**Application by North Somerset Council for an order granting development consent for the Portishead branch line -
MetroWest phase 1**

**Planning Inspectorate reference TR040011
Interested party reference PORT-S57657**

**Comments by First Corporate Shipping Limited trading as The Bristol Port Company (BPC) on the Applicant's responses at
Deadline 3 to BPC's written representation**

19 January 2021

Project: THE PORTISHEAD BRANCH LINE (METROWEST PHASE 1) ORDER
 Sheets: COMPOUNDS, HAUL ROADS AND ACCESS TO WORKS PLAN SHEET 5
 M5 OVERBRIDGE

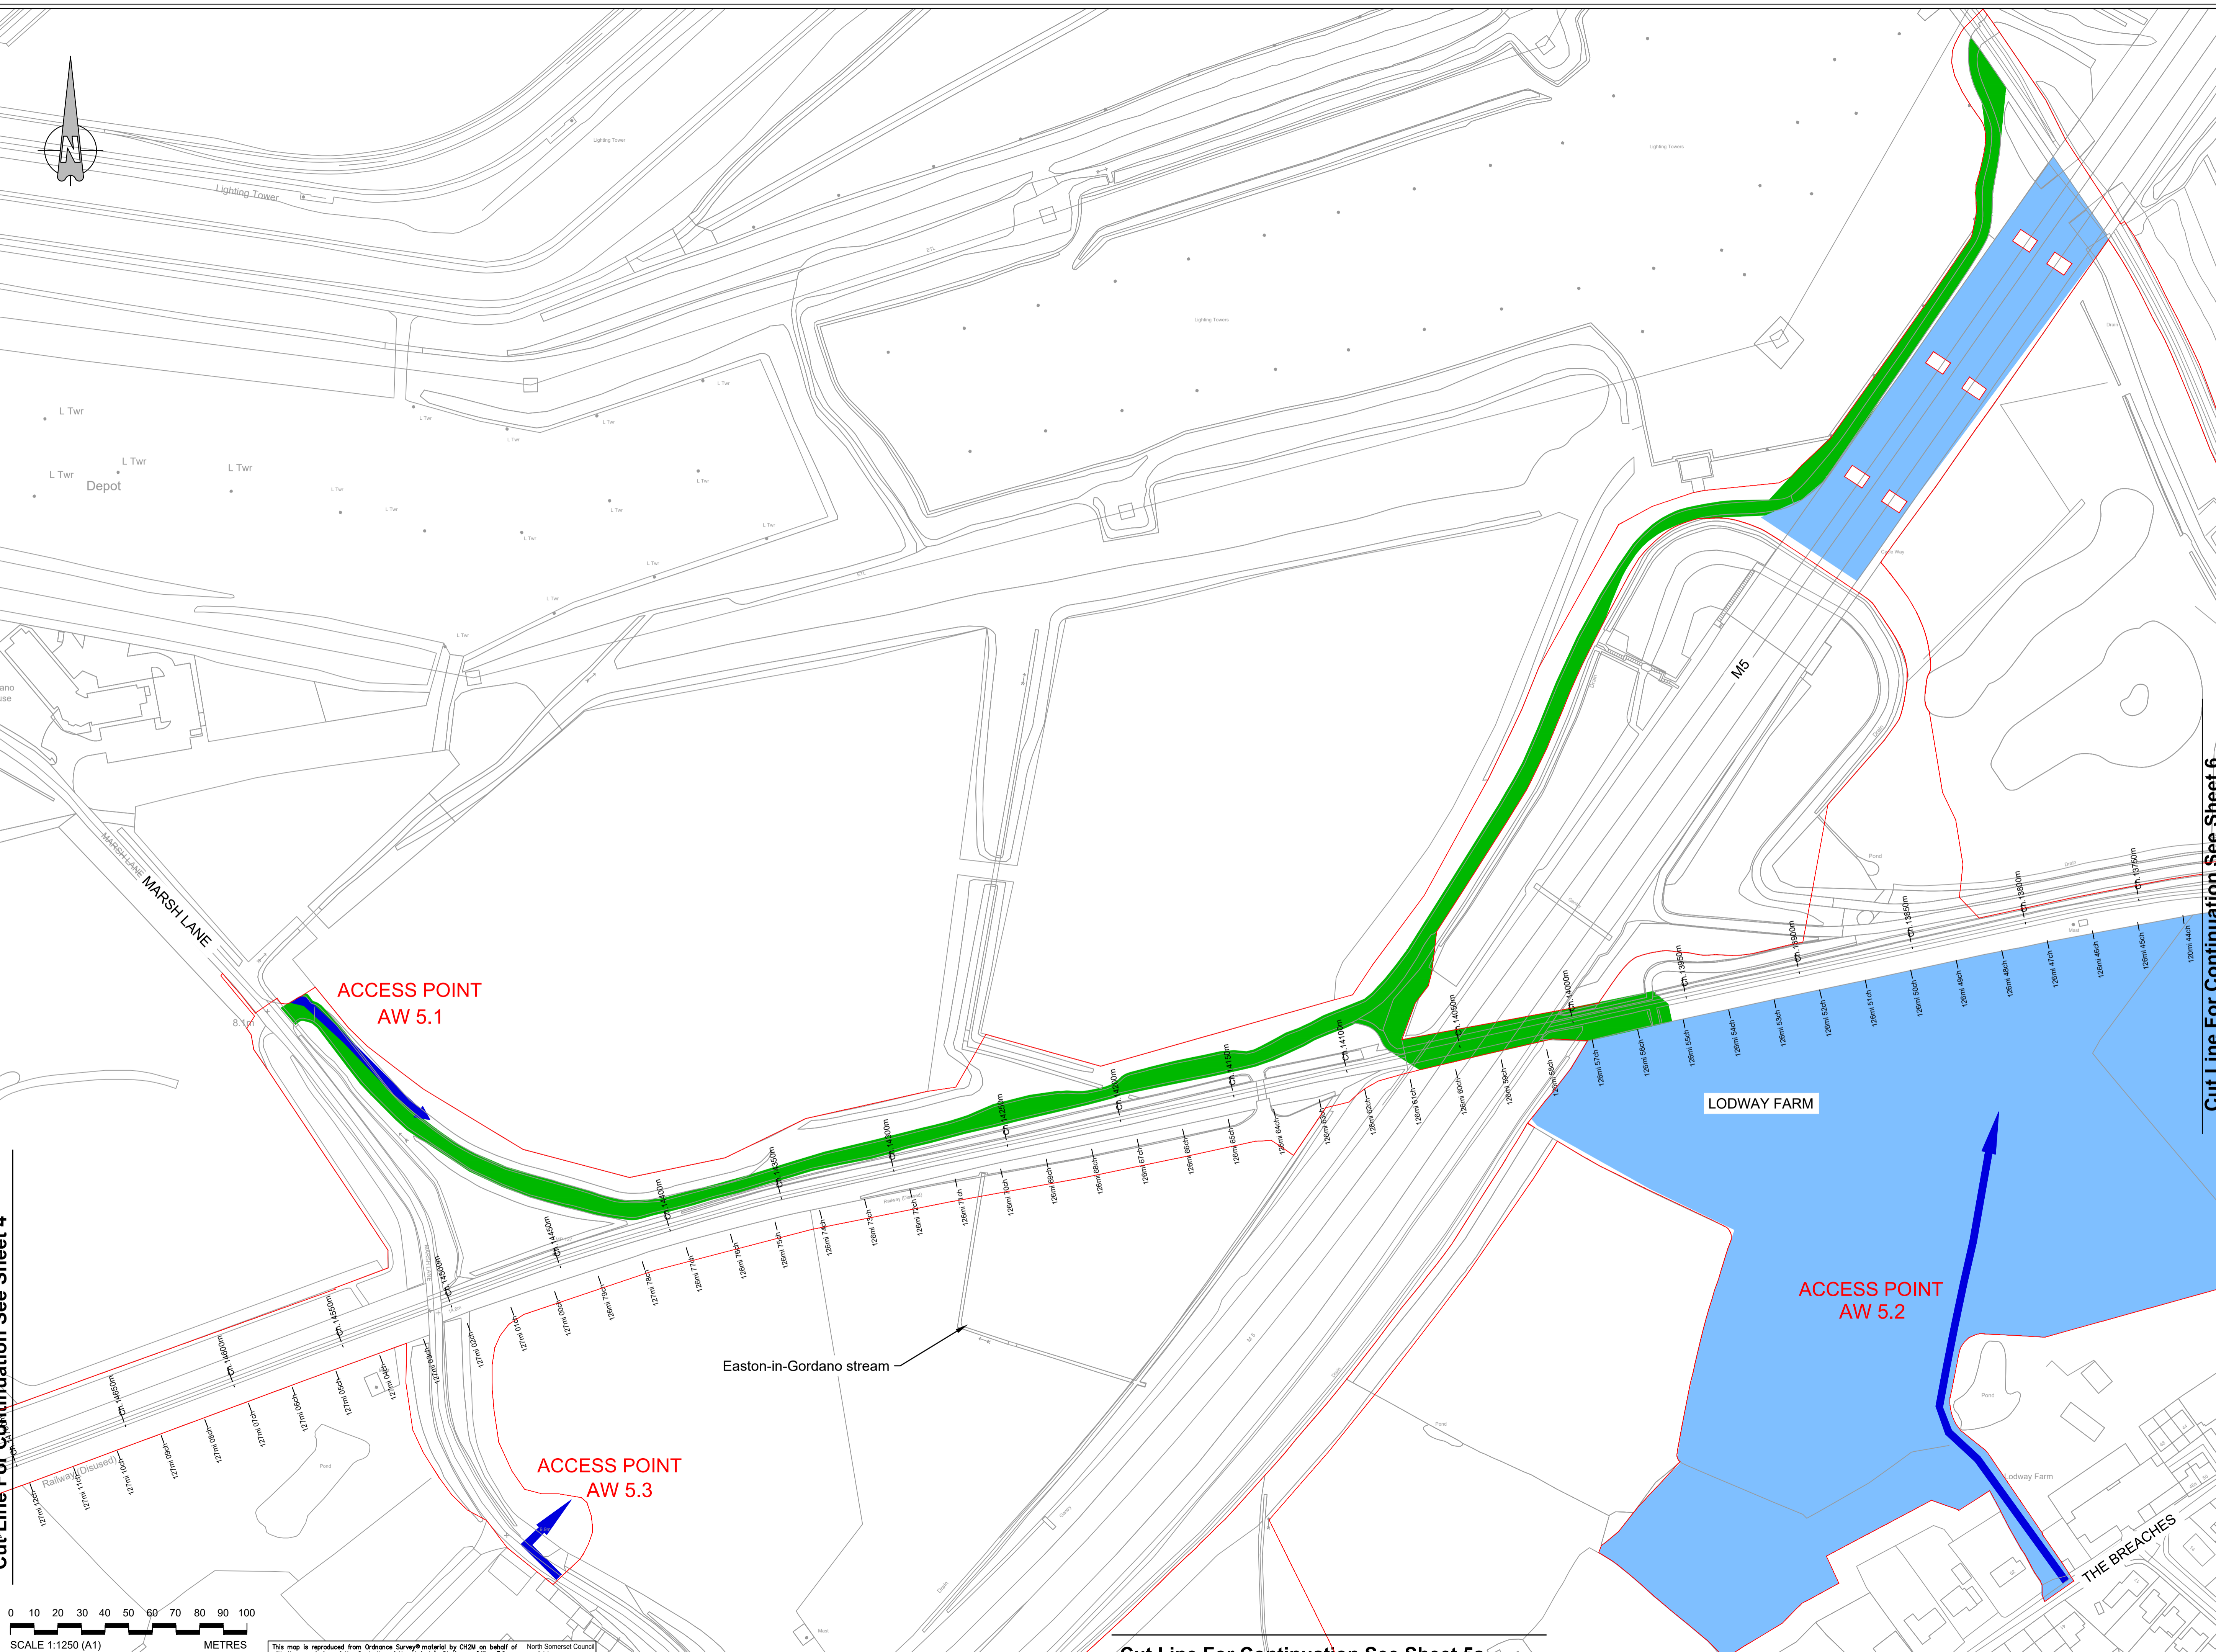
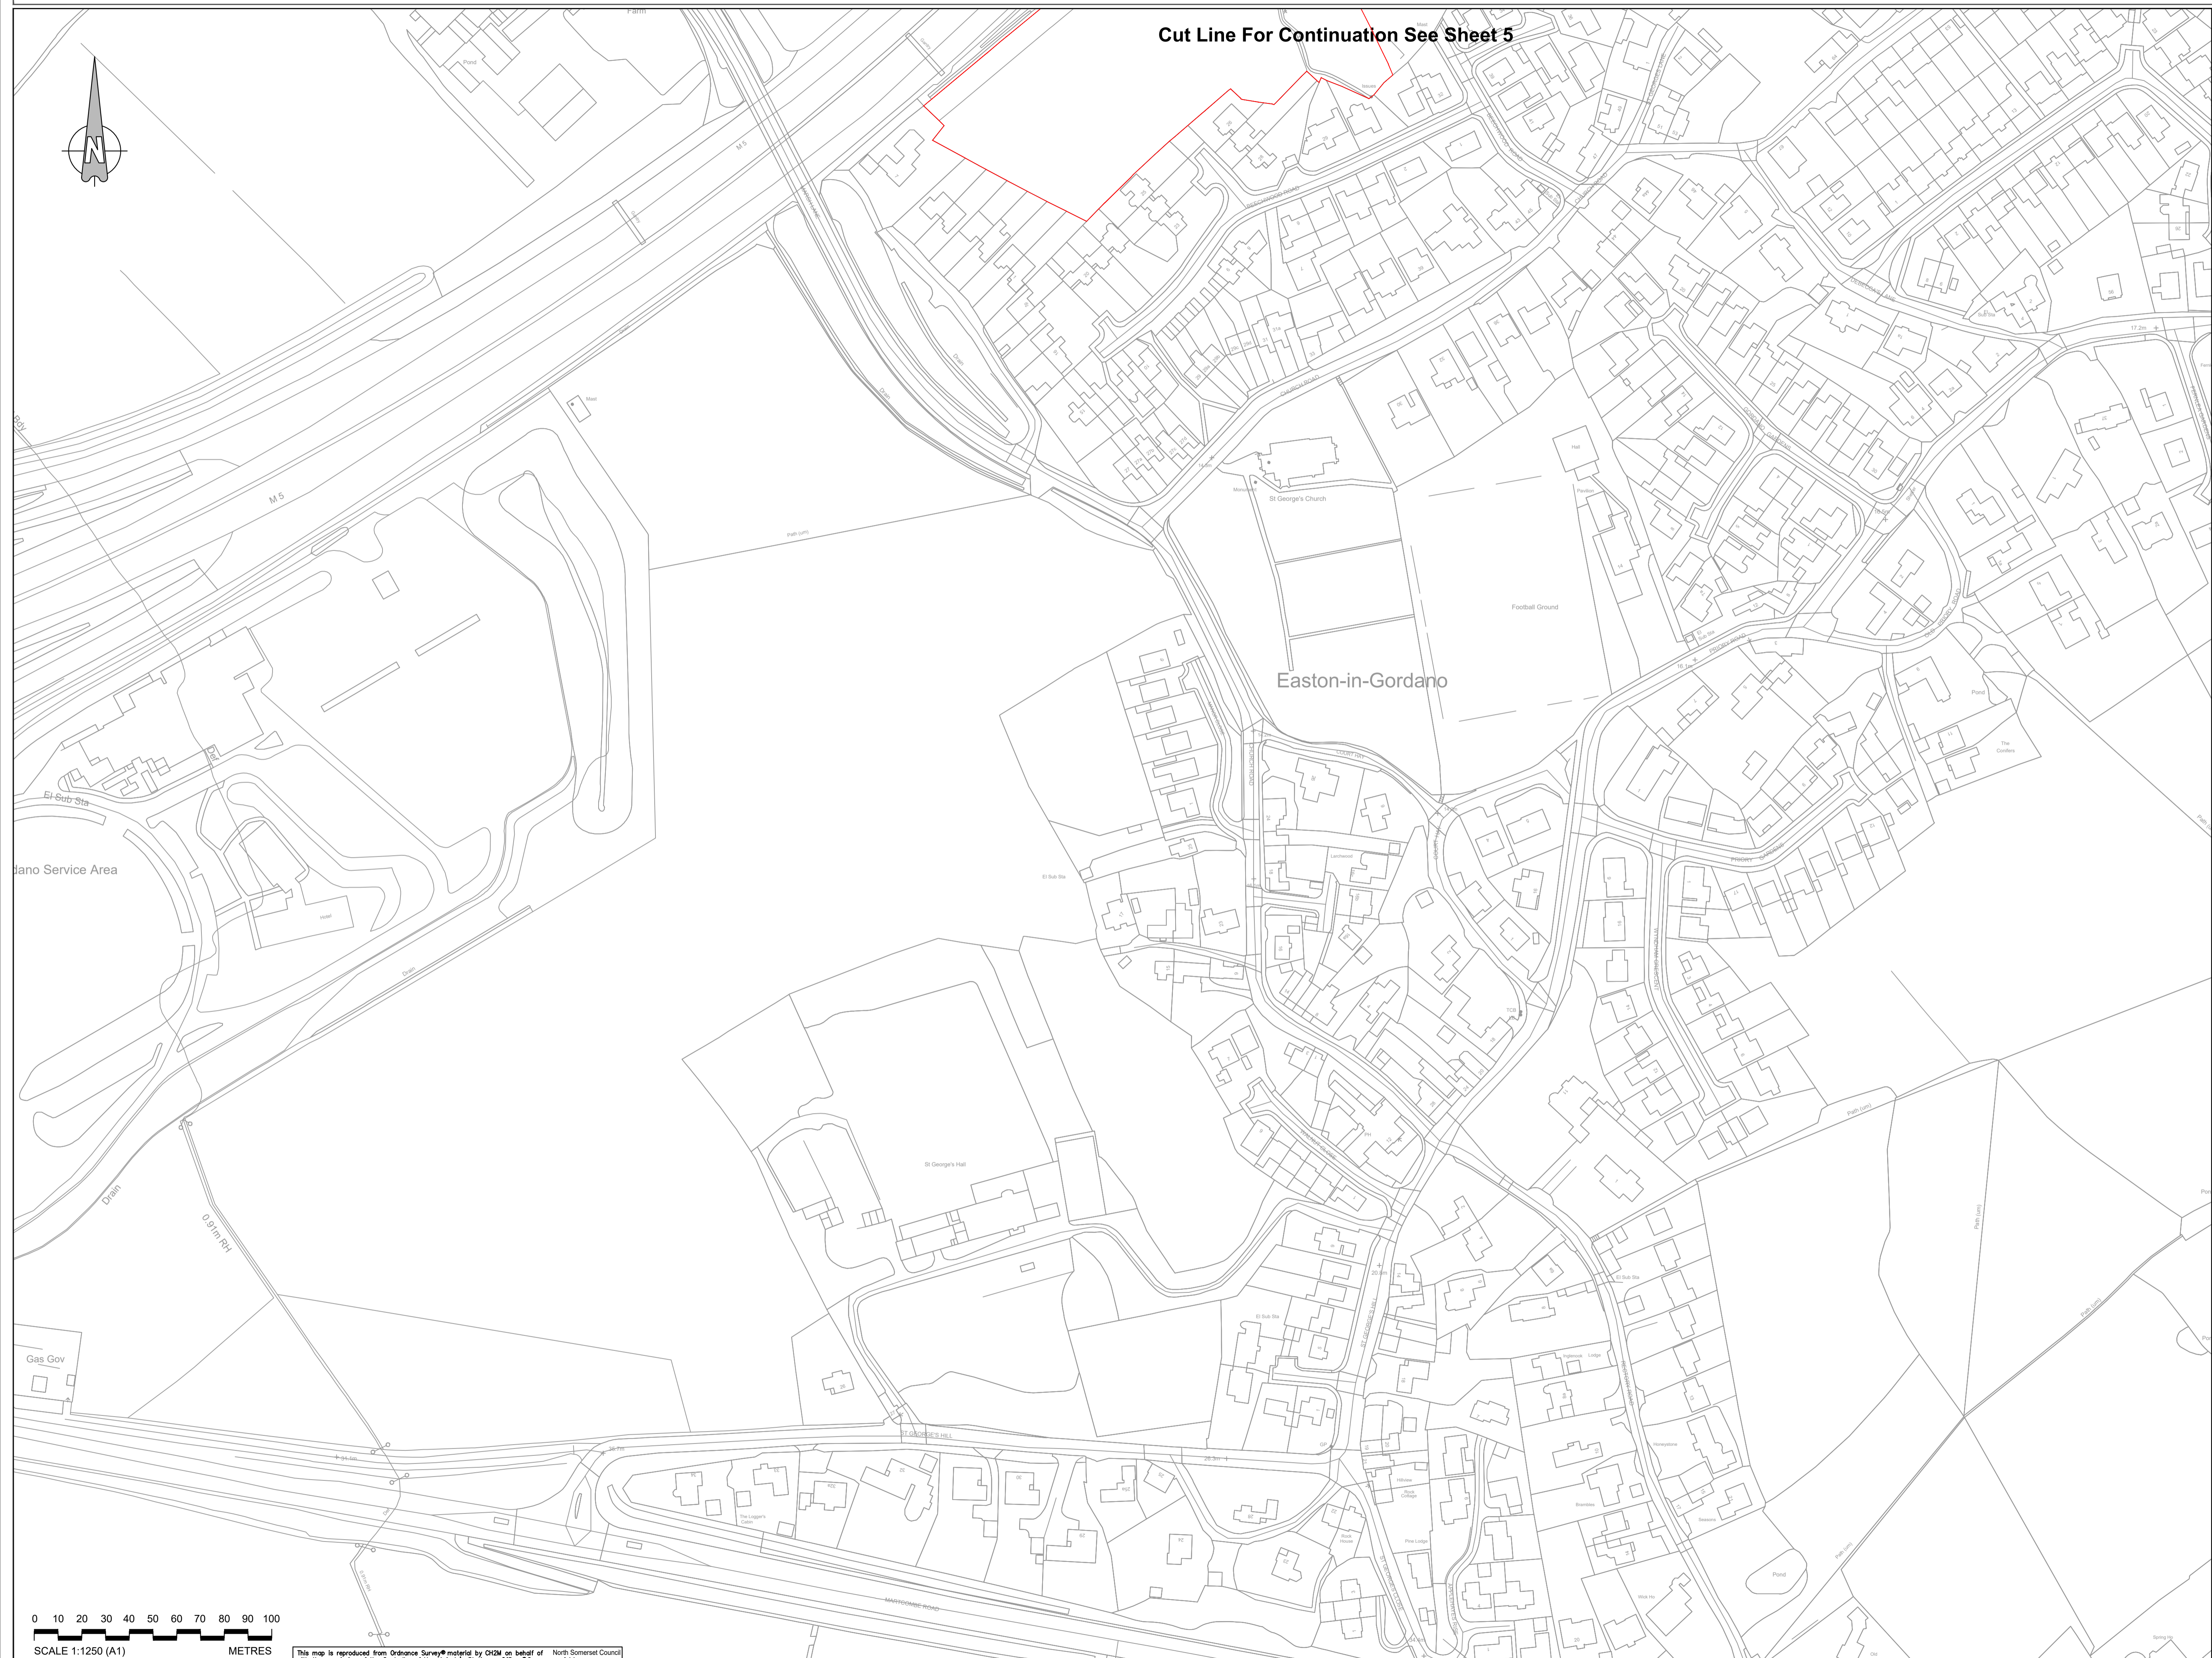
5.7 The proposed location of a construction compound on BPC land beneath the M5 overbridge will interfere with the need for access and impair the security integrity of the RPD Estate.	5.7 The Applicant does not believe this publicly accessible land being used for a compound would have any impact on the security and integrity of the area.	See BPC's comments about security within the dock estate at BPC-D2-002 para 2.1.8 above.
		The Applicant will review the proposed Protective Provisions but has already included its own proposals for Protective Provisions in the draft Order which it
